# Agenda Item 8

**Address** 75A BRIDGE ROAD UXBRIDGE

**Development:** Conversion of existing commercial premises into 3 x residential flats as units as Class C3 Use. Removal of existing front exposed fire escape staircase and amending front and side first floor windows and new rooflights to crown roof. New garage door to ground floor car park and side access to main residential units with new amenity areas.

**LBH Ref Nos:** 73647/APP/2021/951

DRAWING TITLE
Existing and proposed ground floor plan

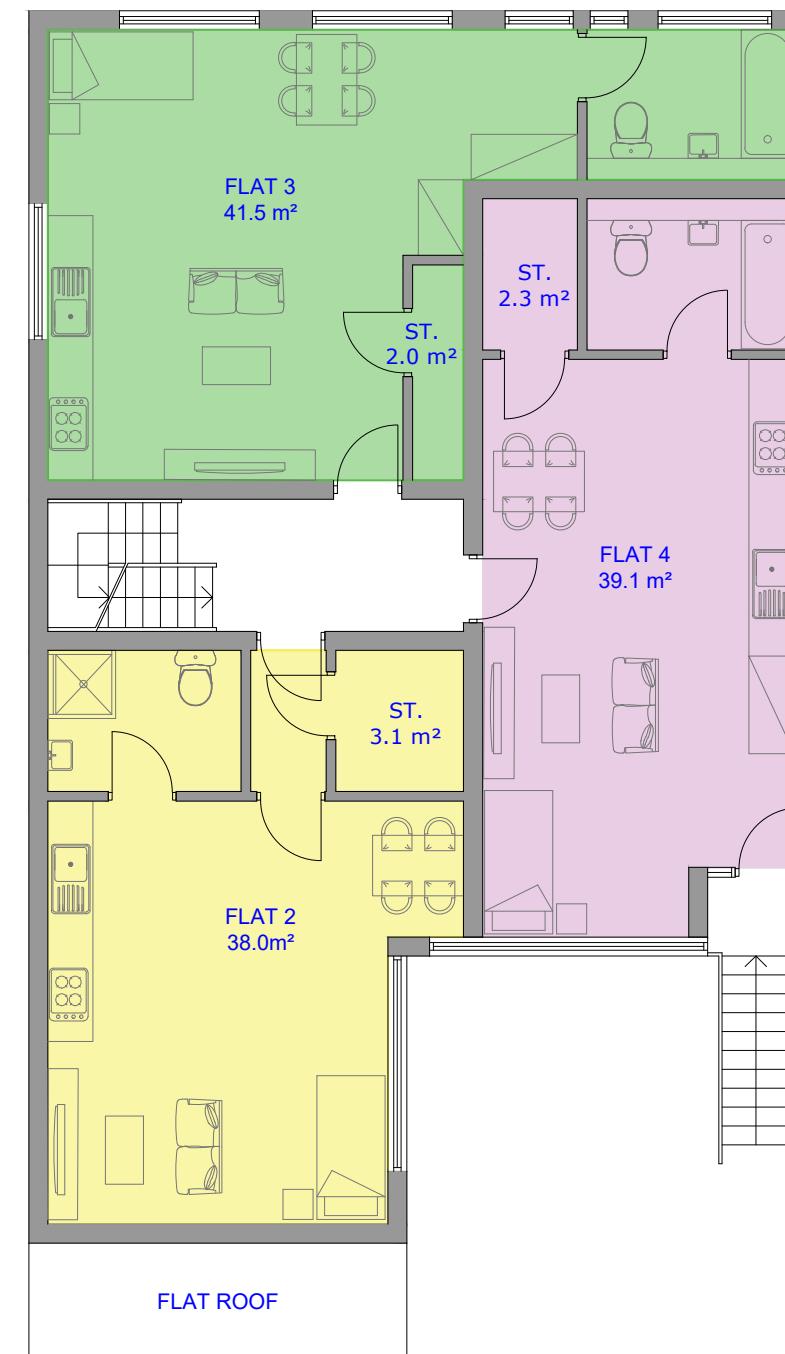
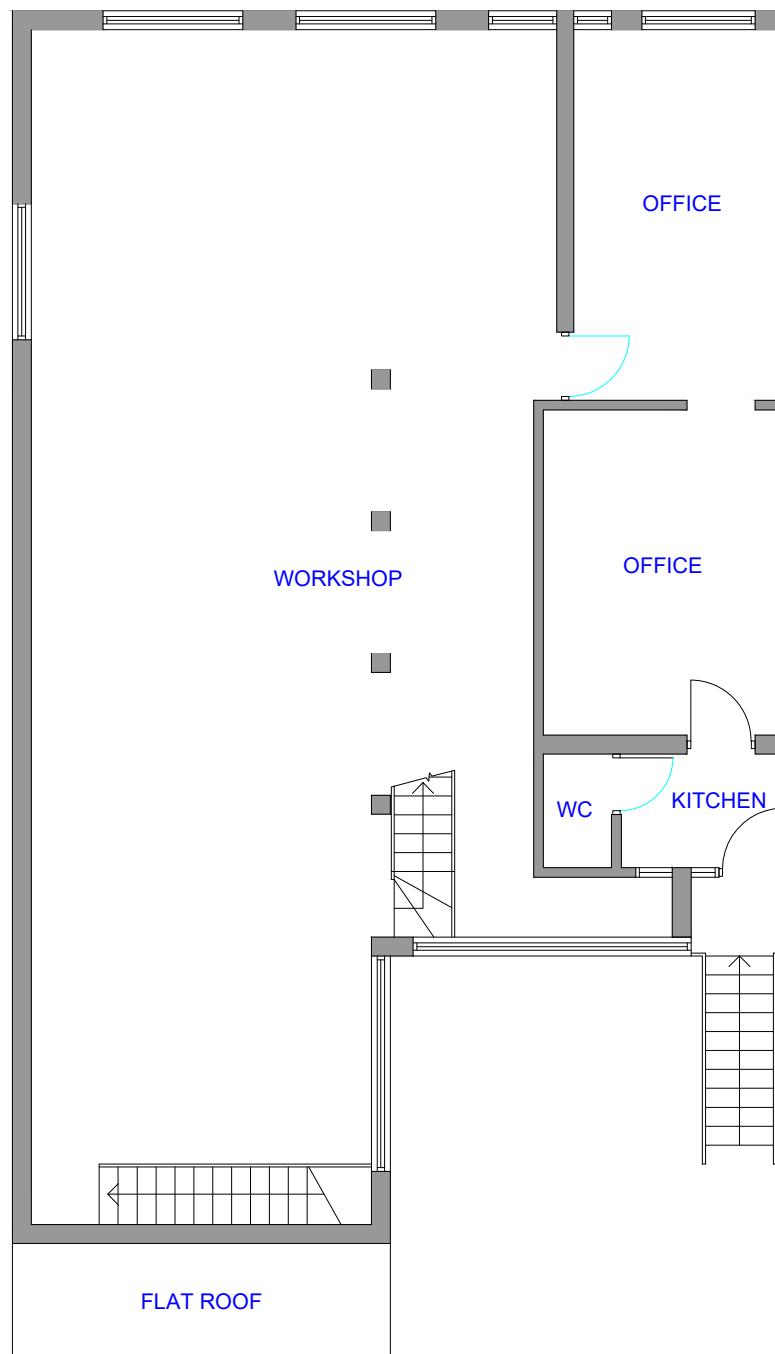
The proposed development includes an excessive amount of parking and is therefore contrary to the Borough's and Government's aims of promoting sustainable forms of transportation. The proposal is therefore unsustainable and directly contrary to Policy

The Hillingdon Local Plan: Part 2 Development Management Policies Policy DMT 6: Vehicle Parking standard would allow a maximum of 5no.space, this has now been superseded by the published London Plan 2021 which allows a maximum of 2.5 spaces. The 5no. spaces proposed is not in accordance with the published London Plan 2021 Policy T6.1 Residential Parking and therefore there are highway objections to this proposal.

The proposal would provide 5 parking spaces, exceeding the recommended parking provisions by 2 spaces. It is therefore considered that the proposal would provide an excessive amount of parking and would be contrary to Policy T6.1 of the London Plan the Boroughs and Governments aims of promoting sustainable forms of transportation and reducing carbon emissions.

DRAWING TITLE
Existing and proposed first floor plan

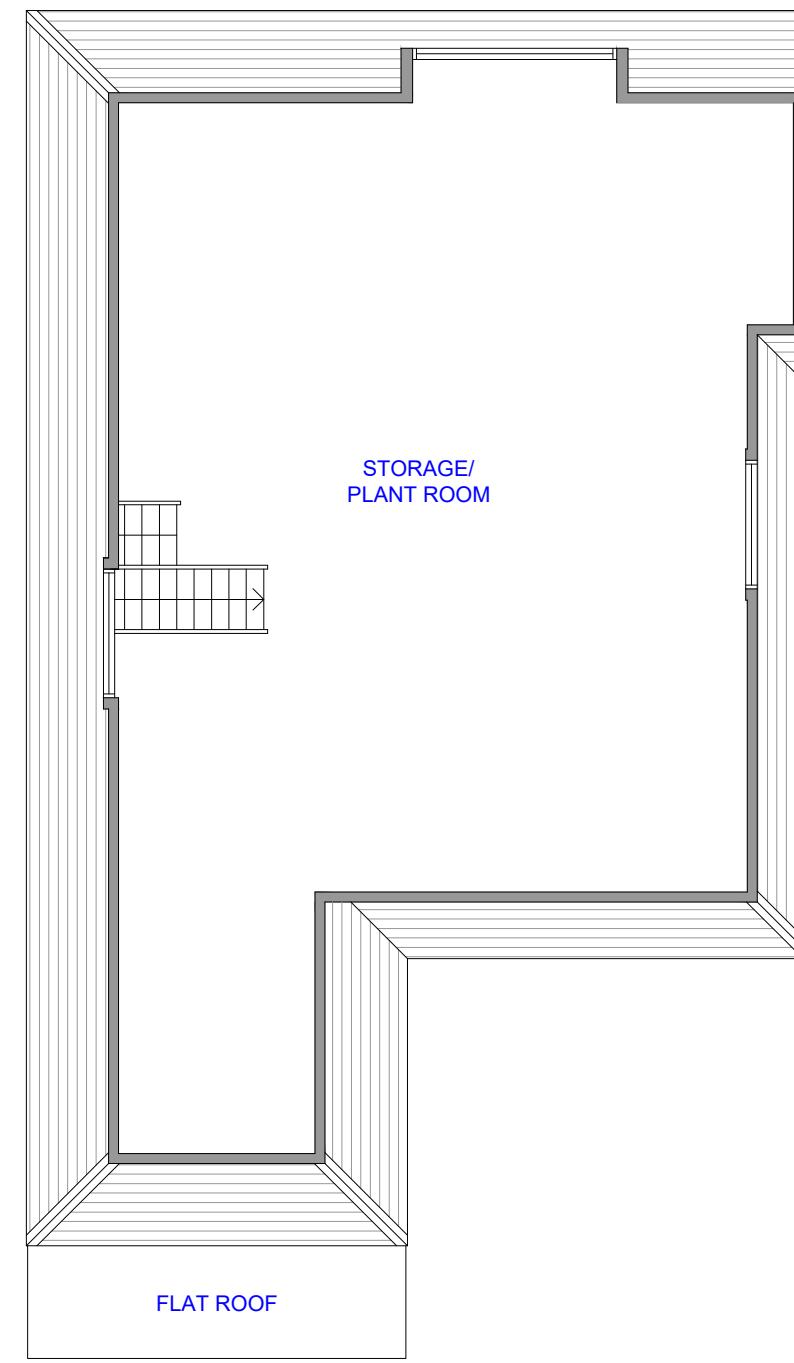
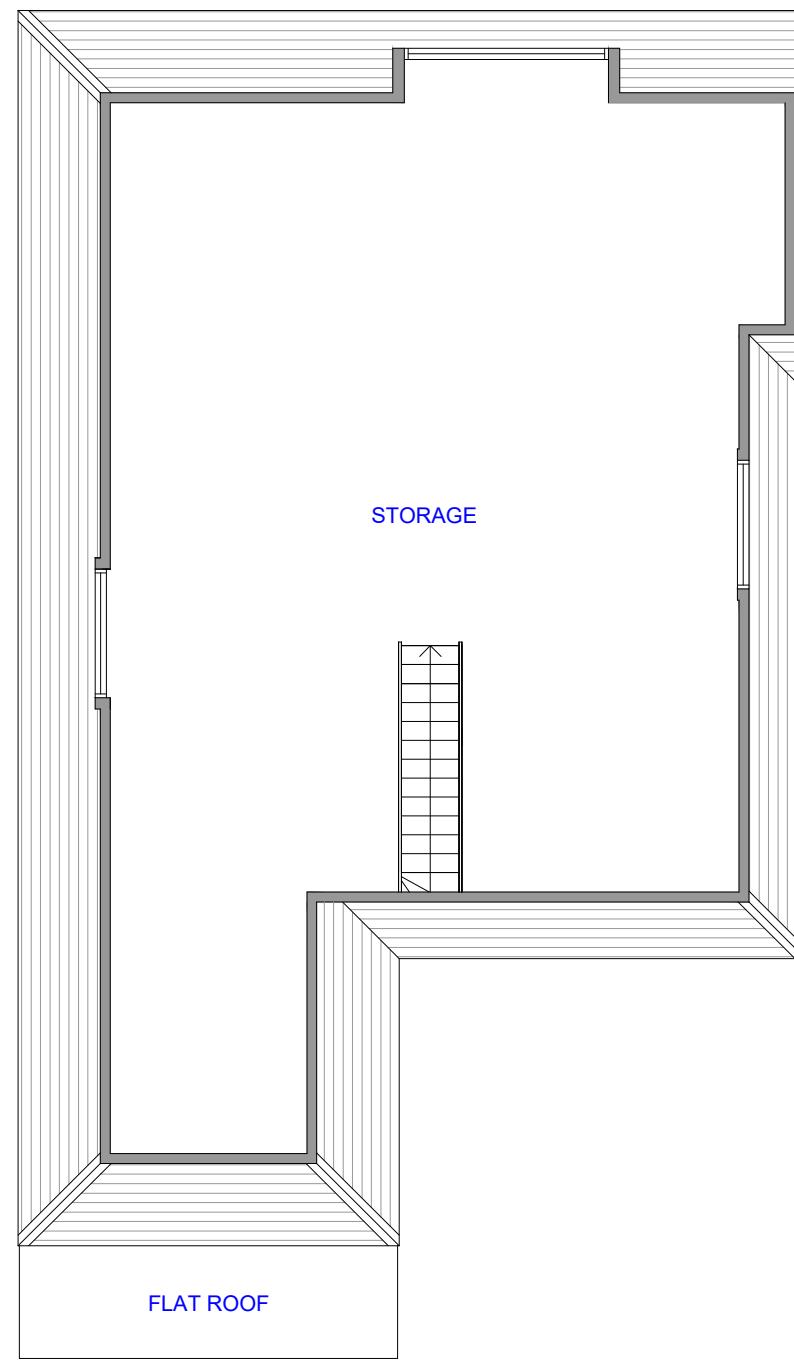
Notwithstanding the above, the west facing first floor front elevation windows of the building (serving family living rooms) would provide direct and unimpeded views toward the rear elevation windows of 74 and 75 Bridge Road at a distance of 10m. They would also provide views toward the rear elevation windows of No. 76 and No.77 Bridge Road at a distance of approximately 17m. Taking into consideration the minimal separation distance between the proposed living room windows and mentioned neighbours, it is considered that the proposed development would result in severe overlooking and a significant loss of privacy to the detriment of the amenities of the mentioned neighbours. The same windows would also overlook the rear gardens and patio areas of No.74, No.76 and No.77 Bridge Road at even less of a distance. The resulting overlooking would cause a significant loss of privacy to occupiers of those properties, discouraging them from using their external amenity spaces and harming their amenities.

Flat A of the proposed development is a 2 bedroom, 4 person property set over a single floor. Minimum floor space standards in the London Plan (2021) state that such properties should provide 70sqm of internal space. 66sqm would be provided. As such the new dwelling would fail to provide adequate internal living accommodation for its future residents to the detriment of their amenities,

DRAWING TITLE
Existing and proposed loft floor plan

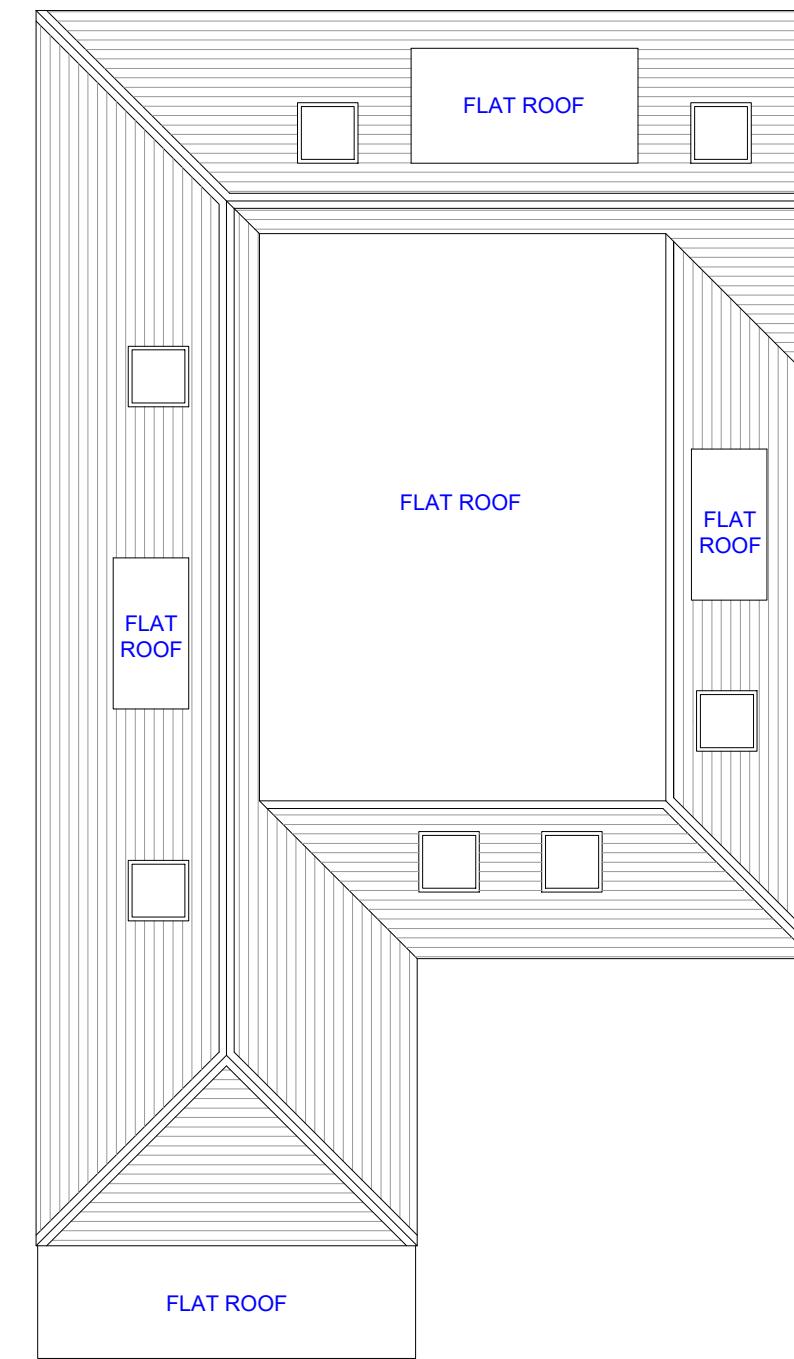
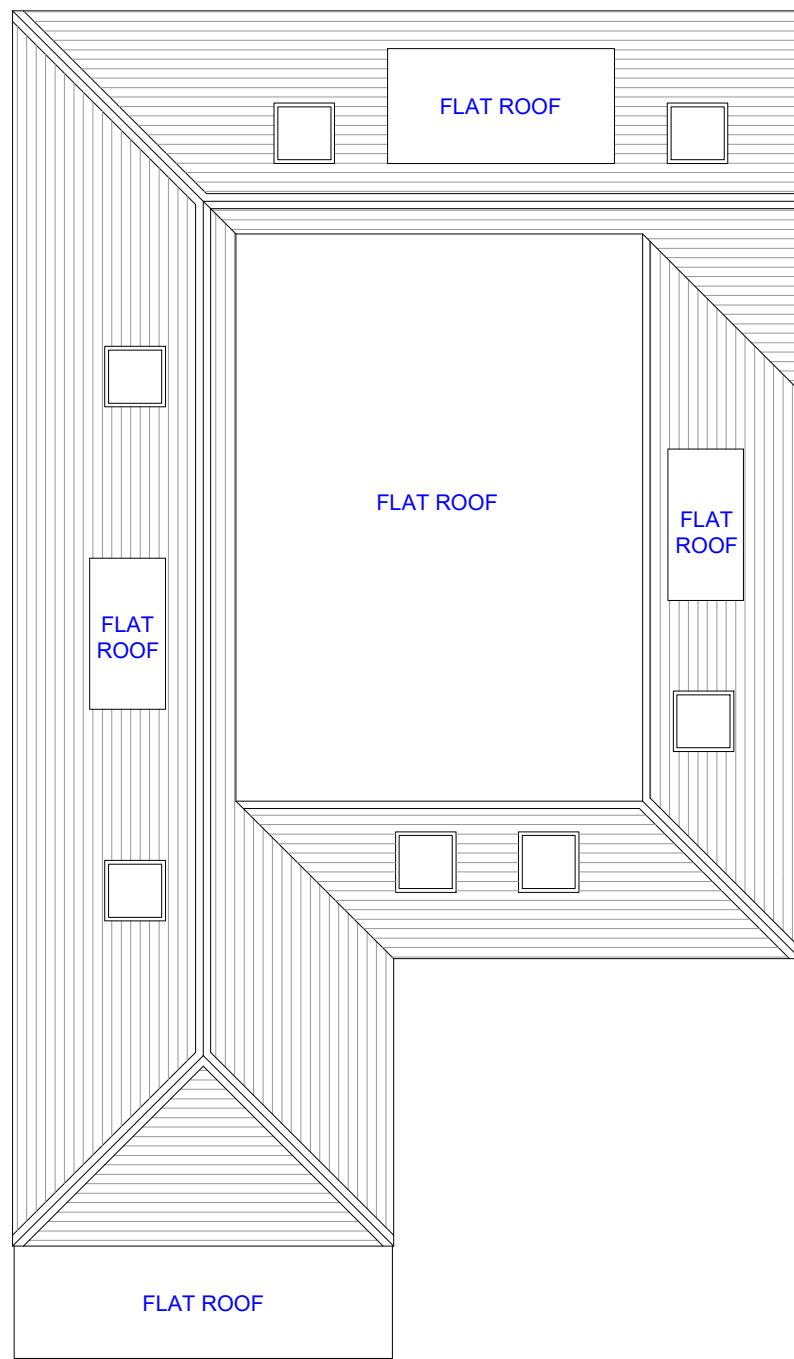
All of Flat C would be accommodated within the roof of the building. The flat's living room and bedrooms would be sited beneath a flat roof section of the building which is 2.4m high from external eaves to ridge. The flat's kitchen, utility room and bedroom would be beneath a steep pitched roof limiting useable space (despite its 2.9m height from eaves to roof ridge). Space would also be needed for heat and noise insulation further reducing head height throughout the entirety of the flat. No clear section plans have been submitted to demonstrate that the floor to ceiling height of the flat would meet the required standards. Taking into consideration the above, it is considered that it has not been demonstrated that the floor to ceiling height in Flat C would meet this requirement set out in Policy D6(F)(8) of the London Plan and it is therefore likely that the proposed flat would provide a substandard level of living accommodation, to the detriment of the amenities of its future occupiers.
